EP/98/15/HH – Little Thatches, 34 Tamarisk Way

We note that a resubmission has been lodged following application EP/59/15/HH and the part which affects us is the extension to the first floor north elevation of 34 Tamarisk Way on which we have written to you on previous occasions. We note that in the revised plans the 900 cm extension results in the wall of the building in question being that much nearer our boundary.

Drawing Number
A.04B TW

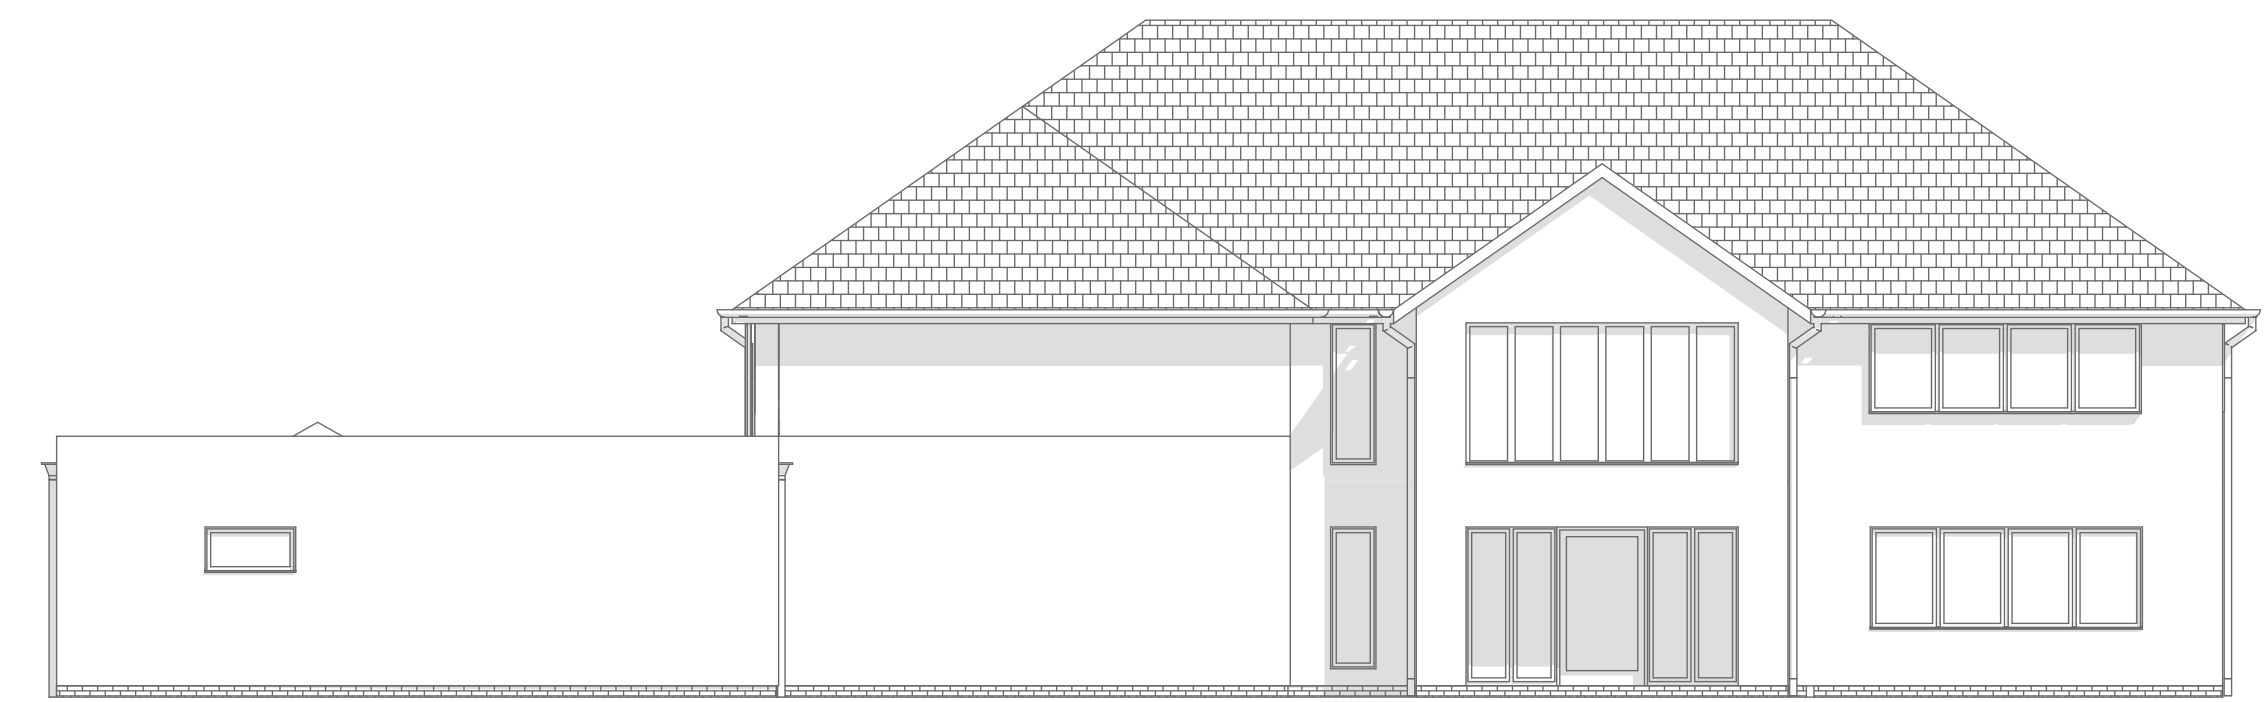
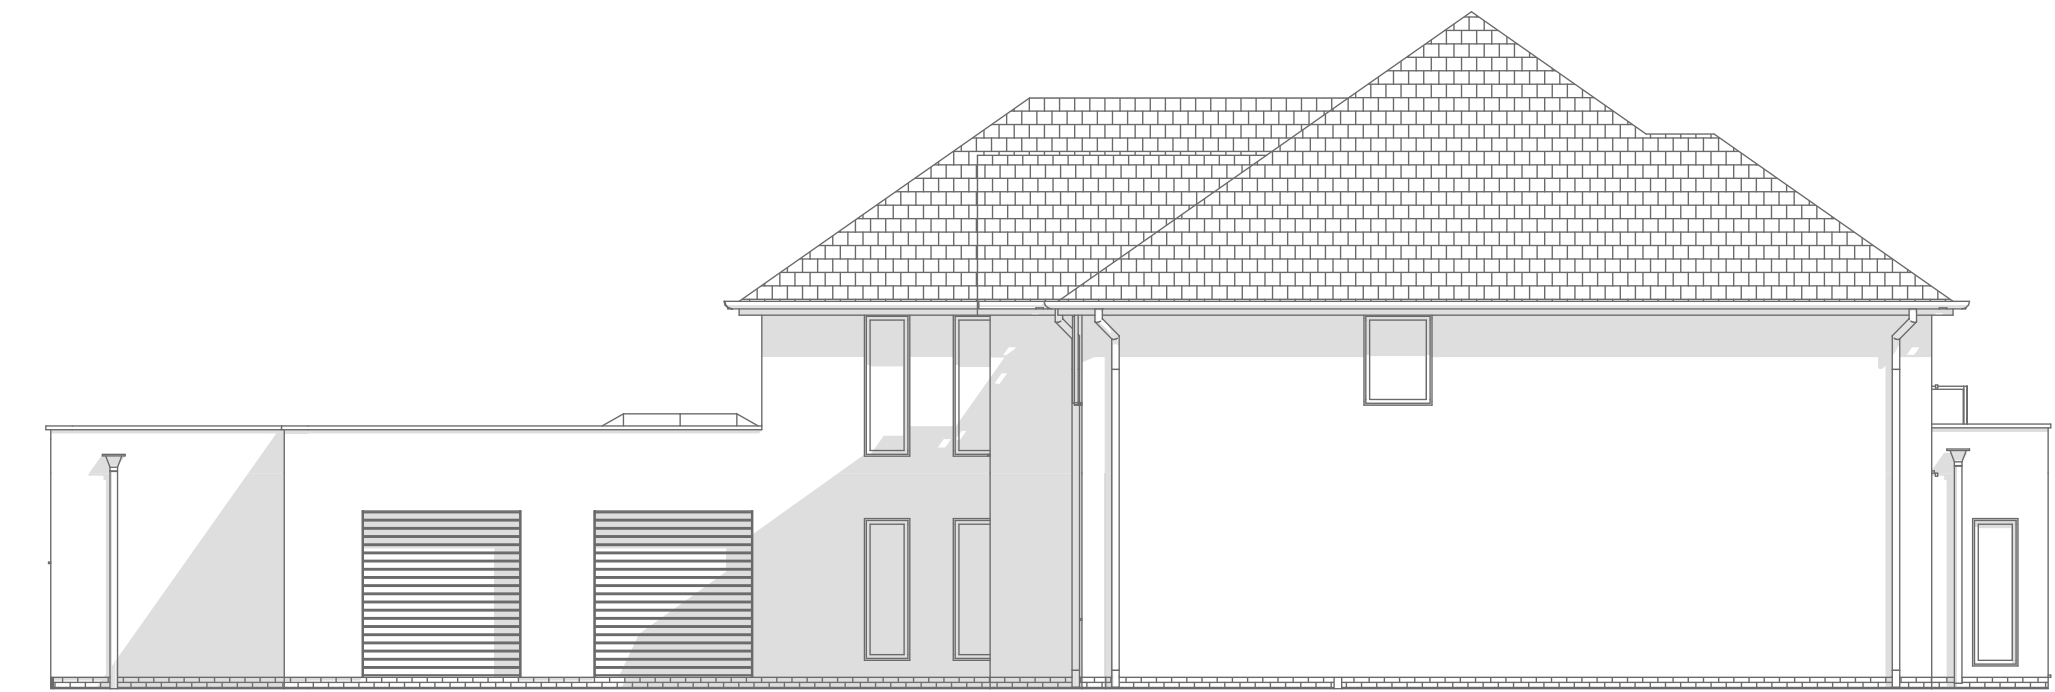
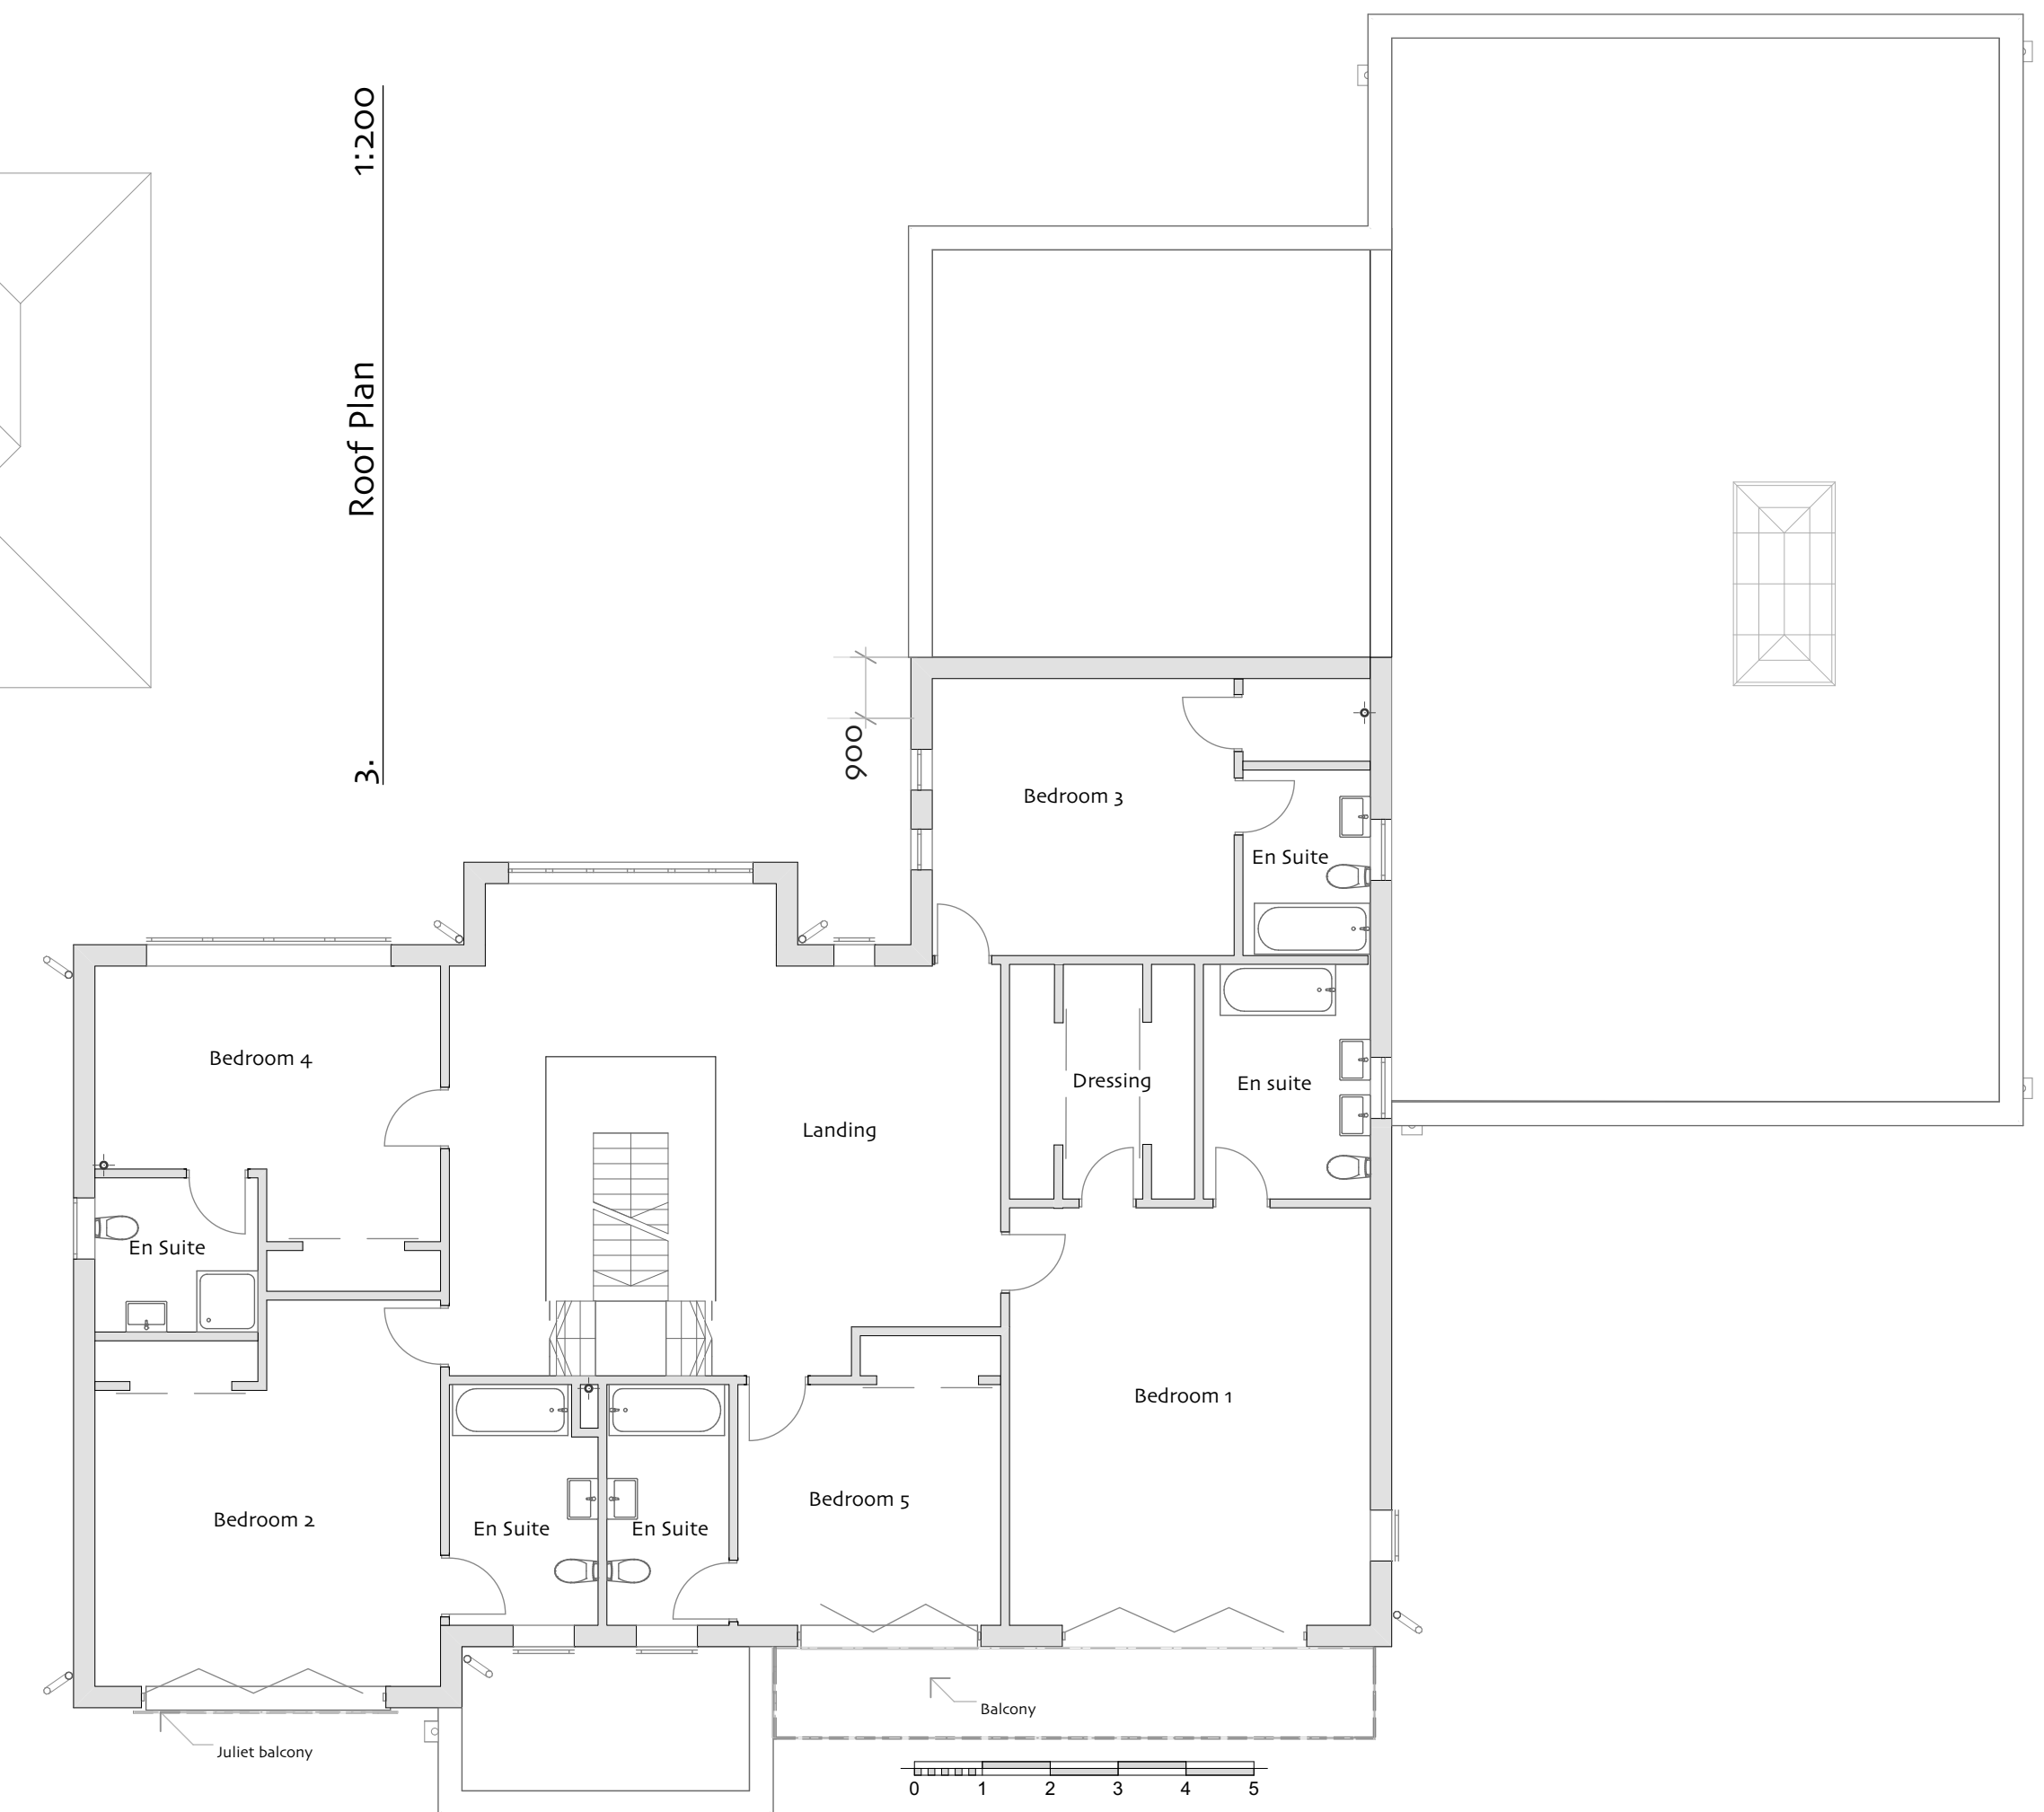
We have earlier commented that with the increase in size of the whole building plot which at one point is only 528cm from our boundary we shall suffer an invasion of our rights to privacy and light and preparatory building work already put in hand demonstrates this quite clearly. The extension requested is directly to the south of our garden and very close to our boundary fence and will blot out the sun to the southern area of our property for a large part of each day.

We urge you to reject this part of the resubmission. You have already passed an application that is deleterious to us and believe that that should be an end to the matter. We feel that, if you allow the increased dimensions, the owners will be back for yet more change until they obtain what they originally wanted. There needs to be a balance between the rights and enjoyment of ourselves and the owners of 34 Tamarisk Way; at the moment we see that balance being tipped more and more towards 34 Tamarisk.
